From: Simon Davis
Sent: 16 August 2019 11:00
To: Planning.Responses
Subject: FW: Nyton House care home dementia ward AL/42/19/PL & AL/43/19/L
Attachments: 18-003 210 P01 - Neighbour Impact 2of2.pdf; 18-003 203 P5 - Proposed Site Plan.pdf; 18-003 206 P5 - Proposed Elevations.pdf; 18-003 209 P01 - Neighbour Impact 1of2.pdf

Subject: RE: Nyton House care home dementia ward AL/42/19/PL

You will see that we have altered the roof form of the new dementia wing in order to pull the apex gables away from the 3m high flint wall boundary with Knighton Grange. In addition we have prepared elevations and views which demonstrate that not only is the impact negligible, it is also no different to the impact on the setting of the neighbour by the existing buildings at Nyton Cottages and Nyton House.

Proposed Elevations

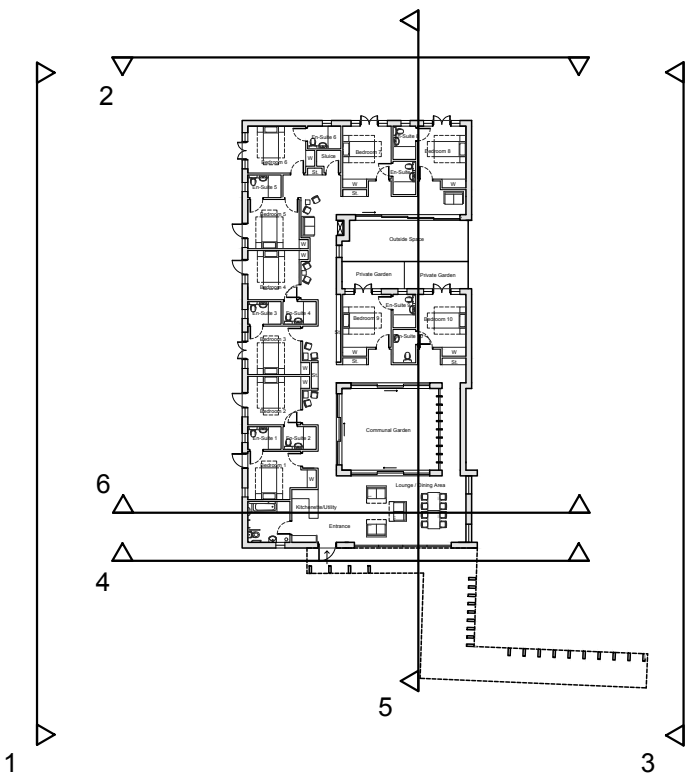
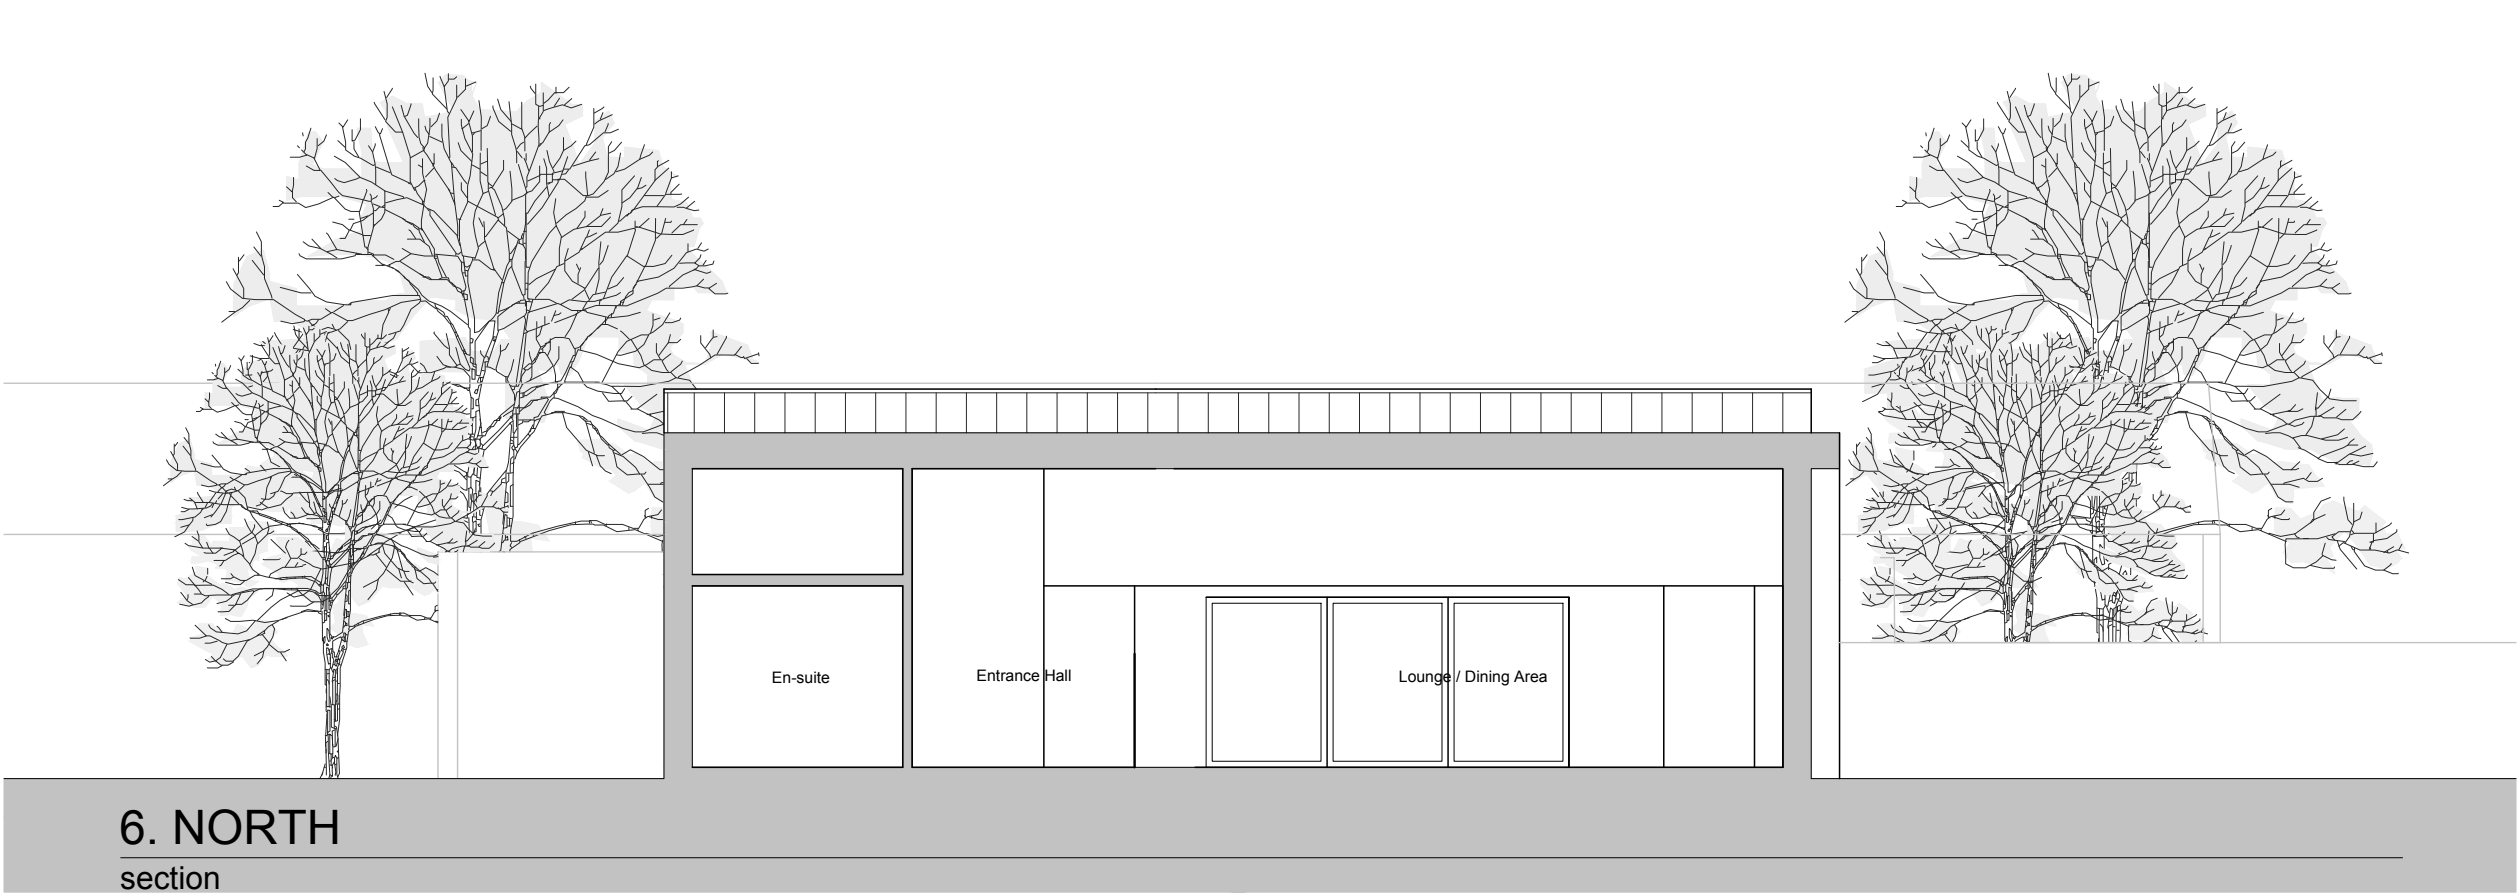
We would welcome the hipping of the western roof gables. This would also reduce the impact on the occupiers of Knighton Grange (they have partly objected to the impact on their view).

Many thanks for this, and indeed to Martyn for his commentary and feedback. Broadly he is supportive of the scheme, which is fantastic. His principle concern relates to the gabled nature of the new building viewed from Knighton Grange Cottage and the harmful impact that this could cause.

I would like to suggest that, in order to reduce this impact further [we have obviously reduced this enormously already from the initial scheme], we introduce hips to the gabled elements of roof. This will slope the roof of the building away from the boundary and reduce the massing of the apex of wall to a sloping roof face diminishing as it moves away from the neighbouring property.
